Vincentia District Town Centre, Stage 1 Modification 8

Timber Screening and Landscaping Amendments
State Significant Development Modification Assessment
(MP 06_0025 MOD 8)

December 2020

drawing title
OPTION 01 - DETAIL SIGNAGE
ELEVATION

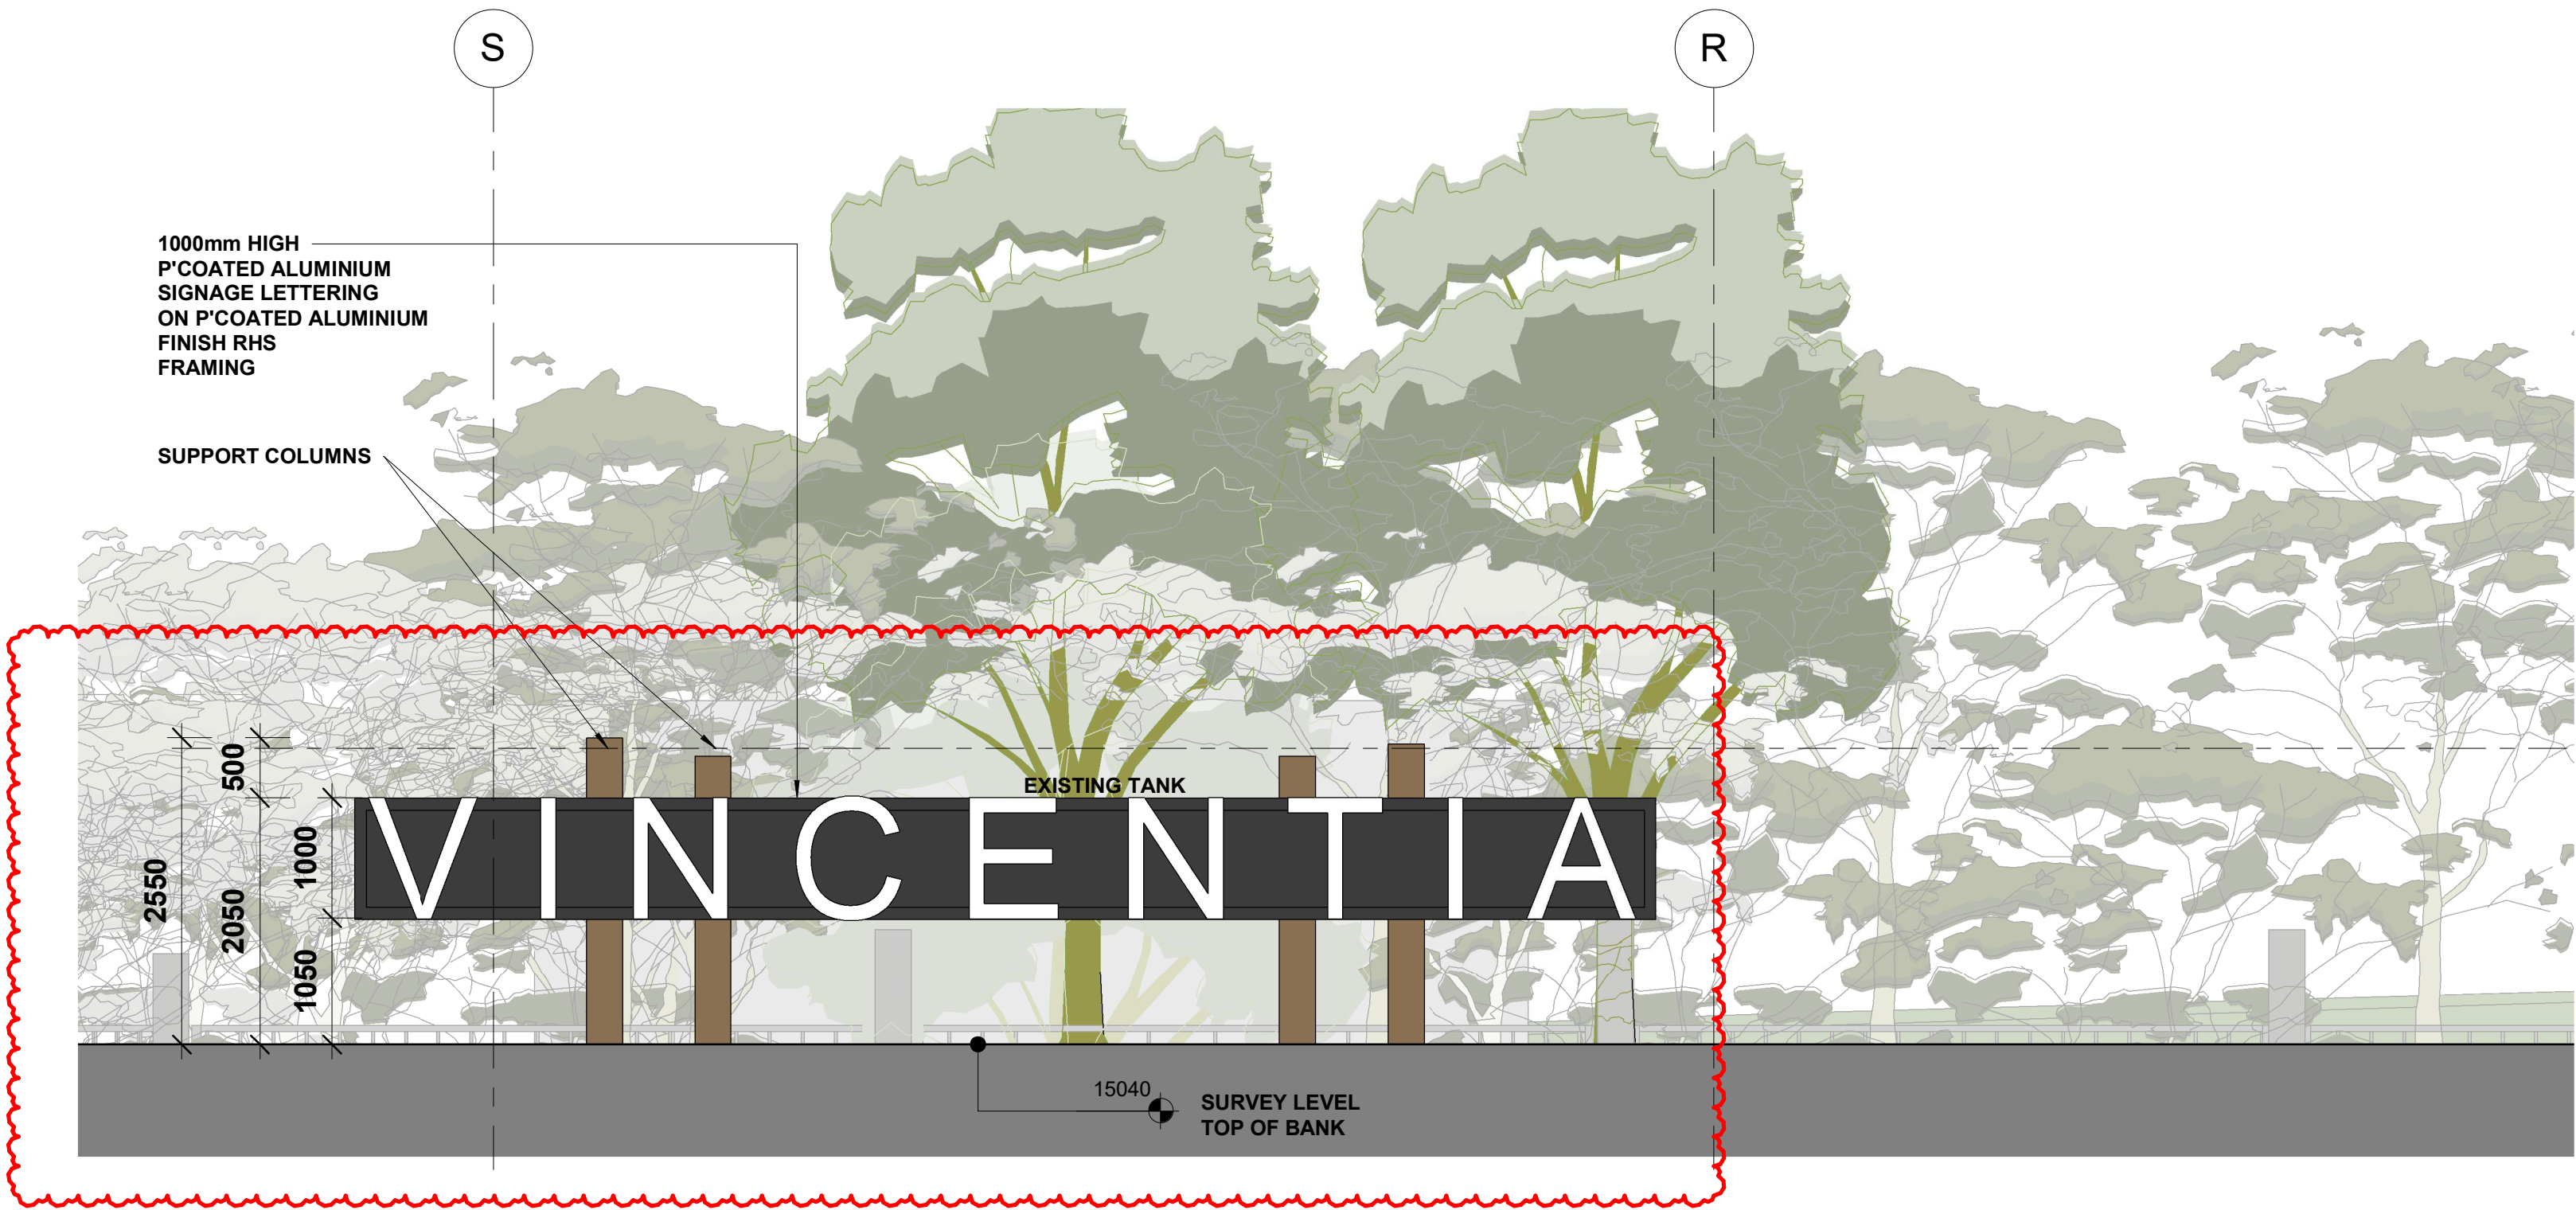
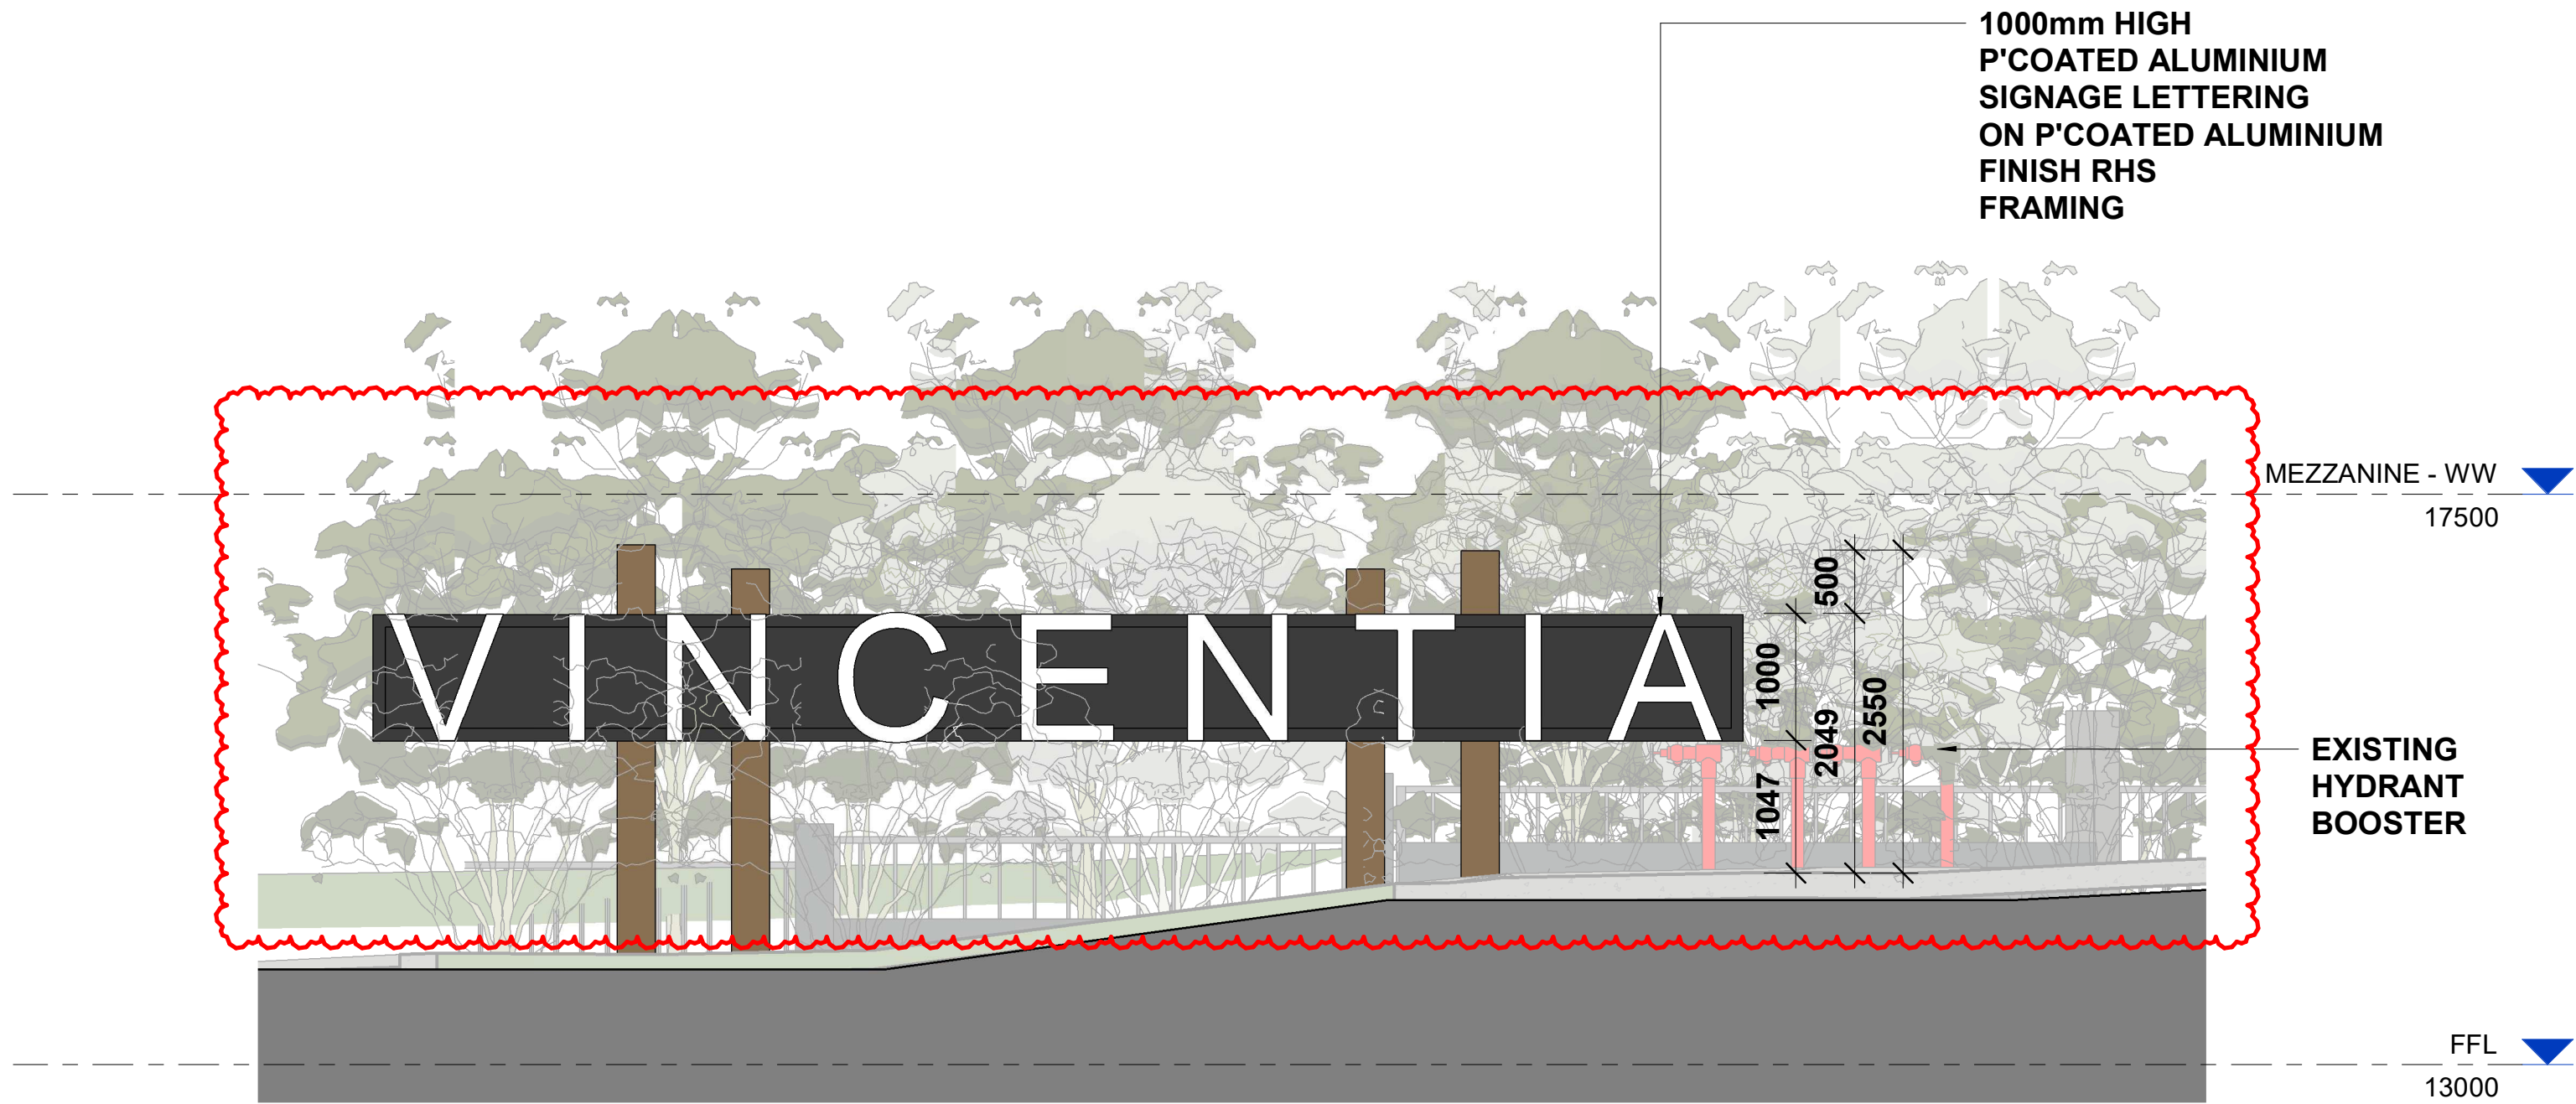
- The signs are excessively large and constitutes visual clutter.
- The signs are at the rear of the shopping centre, rather than the entrance.
- The signs don't appear to serve a purpose other than screening.
- The signs do not fit with Council's signage strategy and have no relevance to Bayswood Estate or the larger Vincentia village.
- A preferred outcome would be increased plantings to thicken the screen and/or the provision of a decorative screen with no words.

In response to Council's submission, the proponent removed the proposed signage and amended the landscape plan. The revised landscape plan was forwarded to Council for comment and on 27 November, 2020 Council advised that it is supportive of the changes to the proposal.
